Re: Route 66 Plaza

8521 Central Ave NE

Request for Certificate of Occupancy

30-Day Temporary Certificate of Occupancy- Transportation Development

SHEET NUMBER
AS-1.0

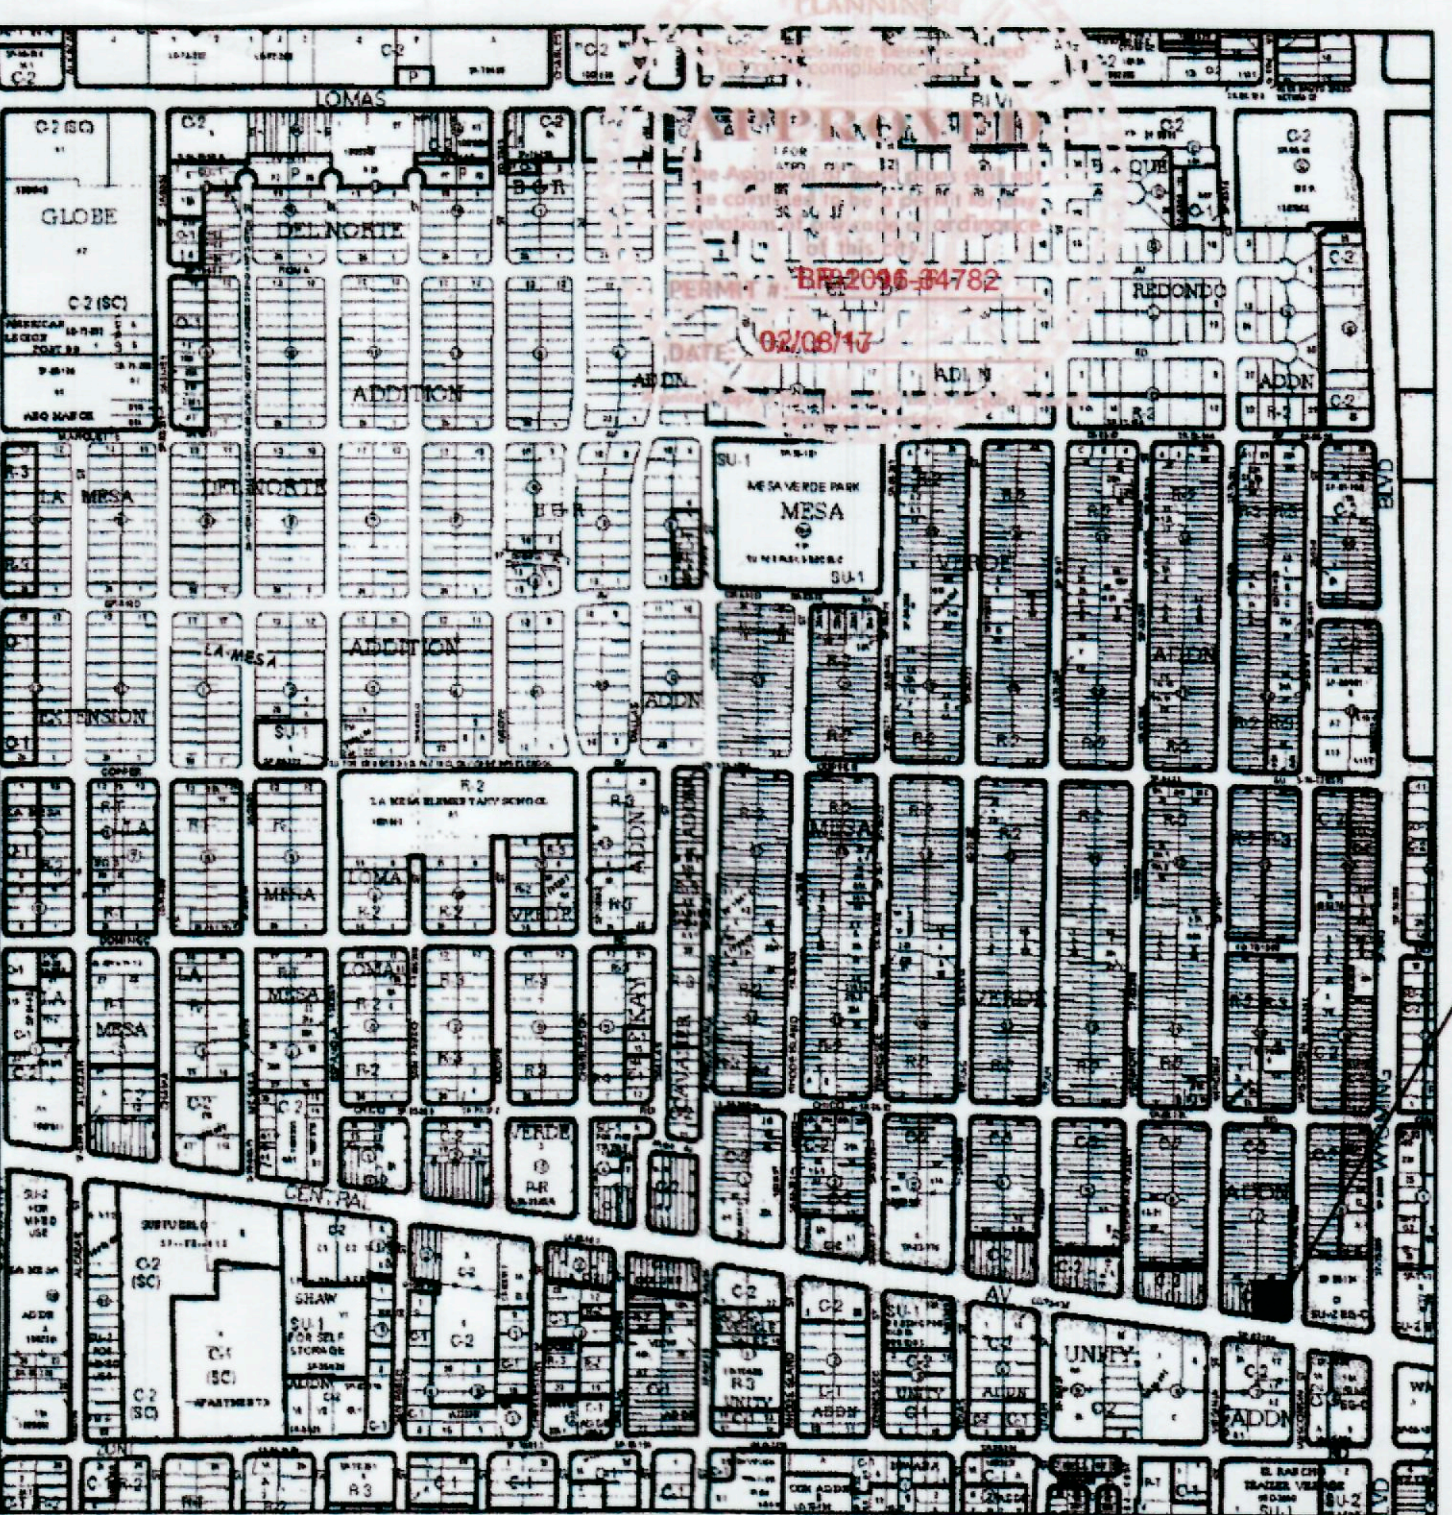
1. Please add bike rack per city standards. (Attached is section 3.11.2 Bicycle Parking)
